From: James Russell
Sent: 19 July 2012 09:22
To: Claire Booth
Cc: John Macholc
Subject: RE: 3/2011/0906 - Dale House, 5 Church Street, Slaidburn

RE: Wood burning flue at Dale House, 5 Church Street, Slaidburn (Planning Application 3/2011/0906/P)

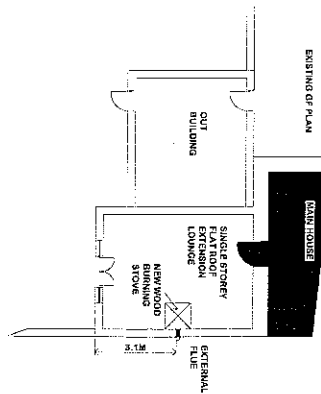
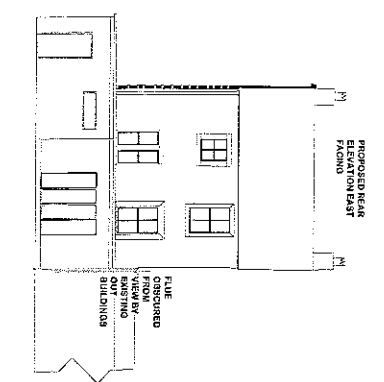
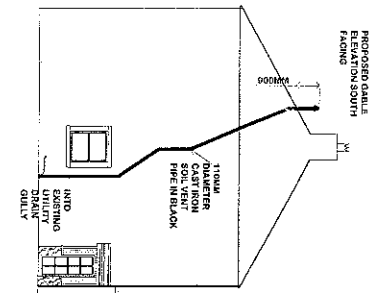
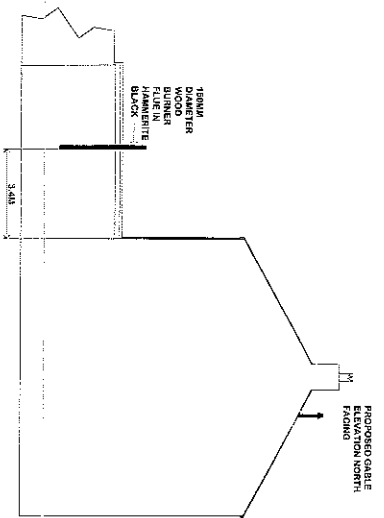
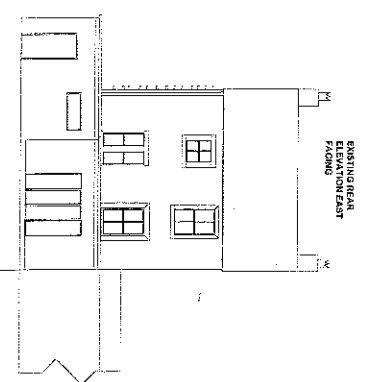
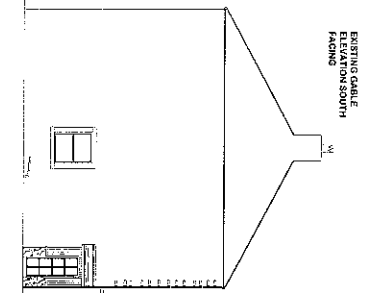
I acknowledge that the appliance may meet both building regulations and HEATAS requirements but I believe the application should not be approved due to poor dispersal of products of combustion and potential for significant nuisance to neighbouring properties due to the enclosed nature of the site and enclosed adjacent yard areas

I have today received an objection from the Environmental Health department who have raised serious concerns over the wood burning flue proposed on the side elevation of the rear single storey flat roof extension. The Environmental Health department are concerned that the flue would cause significant problems to the amenity of neighbouring properties and the residents of 5 Church Street due to the combustion material not have anywhere to escape other than at this low level as the flue would not project high enough. The Council are therefore within our right to refuse the application on this ground.

The Environmental Health department have advised that your clients should in the first instance consult the manufacturers leaflet to see how high the flue should actually project so not cause a health nuisance.

Notwithstanding this, and without knowing the height, I should make you aware that the planning department is likely to have concerns with increasing the height of the flue as it could be detrimental to the character, appearance and significance of the Conservation Area and wider visual amenity. The best solution all round is therefore likely to involve using the existing chimney stacks at the property.

Dear Claire, I have had a discussion with Nick Astley of Fuelmizas in Ribchester who are supplying the stove to Dale House, and he assures me that the flues are fully compliant with building regulations, and do not pose a threat to the neighbouring or host properties. The height of the flue at 900mm above the roofline is also fully compliant with the specification for the discharge of smoke into the air.
